DRB Application No.: 05DRB-01056 (P&F) Project # 1004280
Project Name: MENAUL PLACE
Agent: Lorraine Baca Phone No.: 299-4875

**CITY OF ALBUQUERQUE
PLANNING DEPARTMENT
JUNE 29, 2005
DRB Comments**

RE: Lot 29, Menaul Place/minor plat

PLAT OF
LOTS 29-A and 30-A
MENAUL PLACE SUBDIVISION

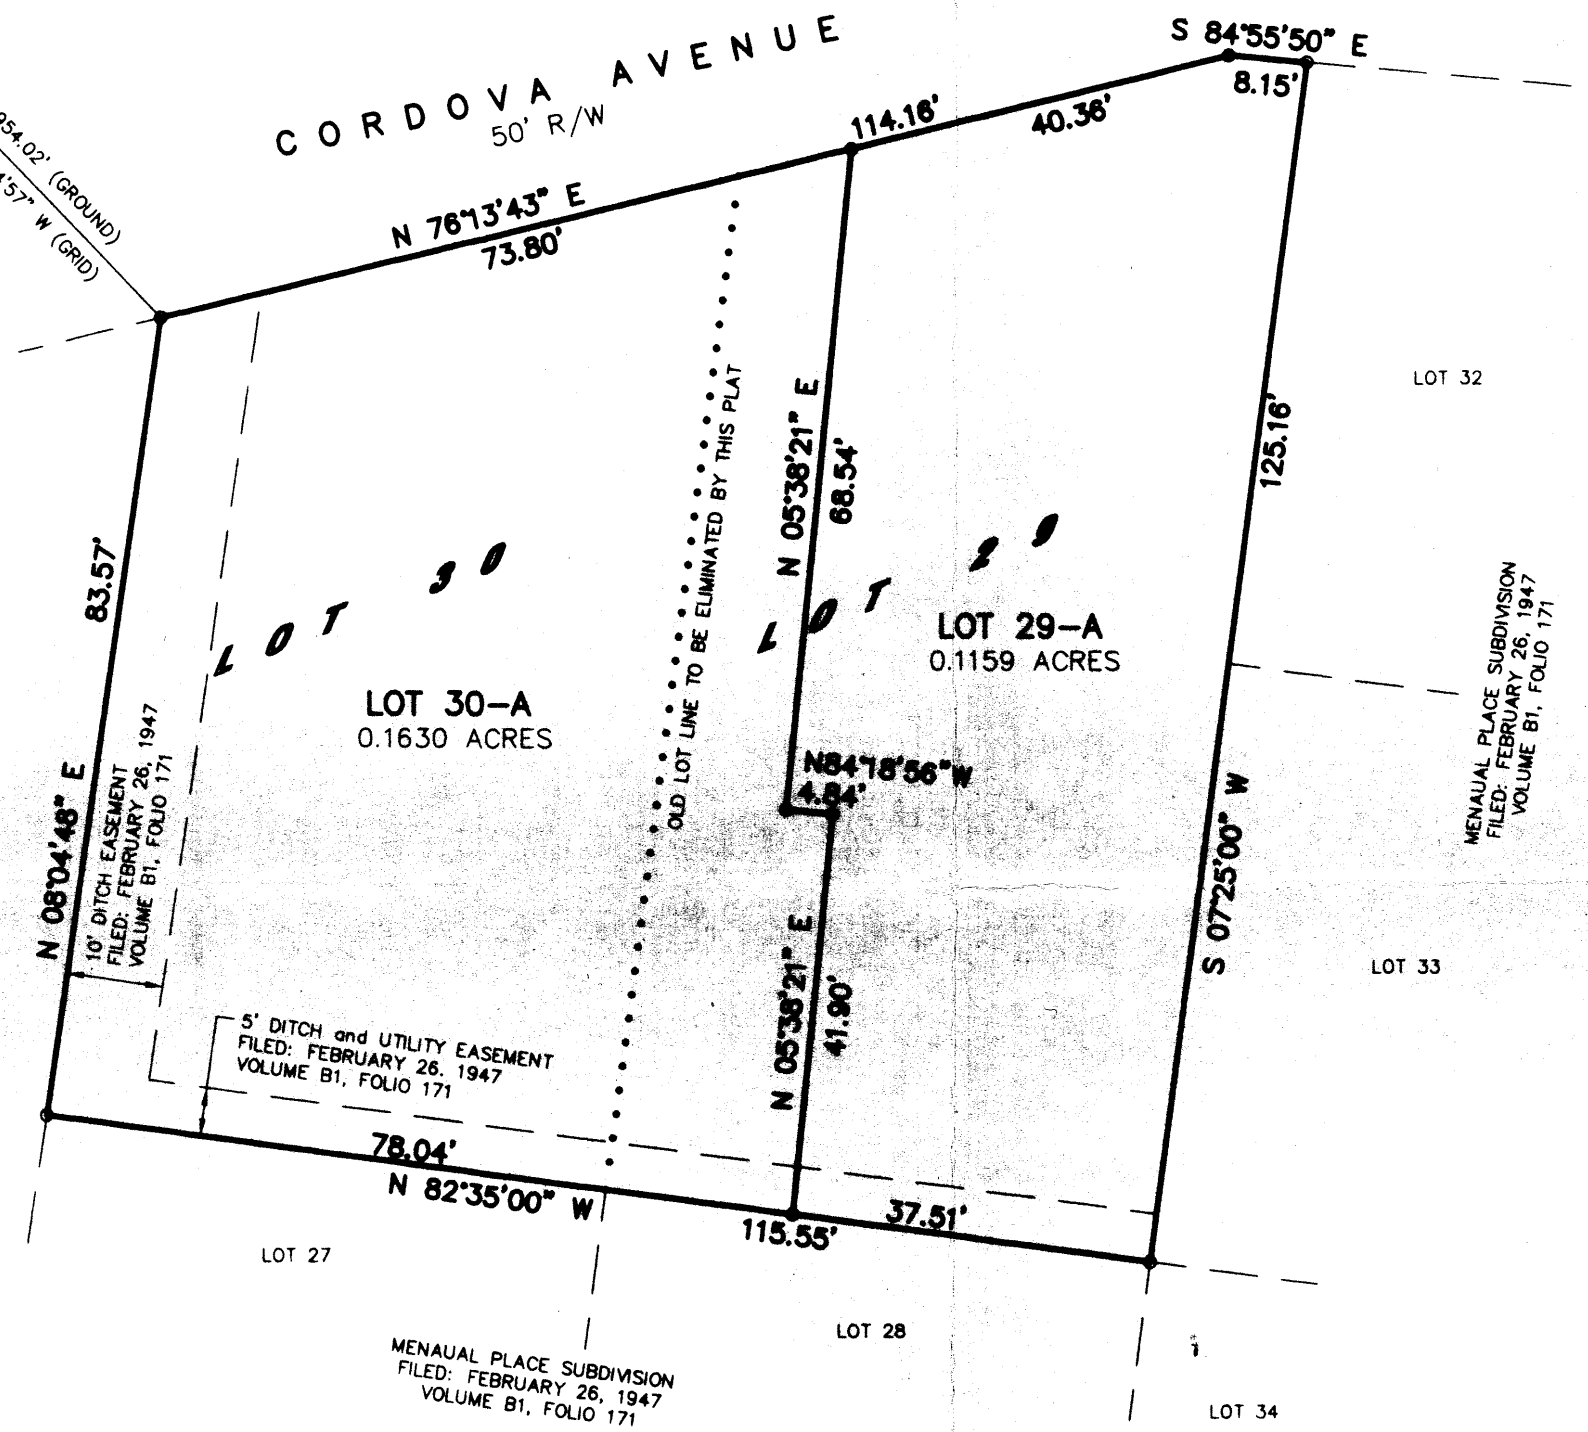
Proposed Lot 29-A does not meet the minimum requirements for an R1 lot. The minimum lot width is 50 feet. Lot 29-A measures 48.51 feet. Planning is willing to approve the subdivision subject to the approval by the Zoning Hearing Examiner of a special exception to allow the substandard lot. Planning would withhold signing the plat until the ZHE approval is granted. If the ZHE does not approve this special exception, the plat would not be recorded. Planning's signature is required before a plat is recorded.
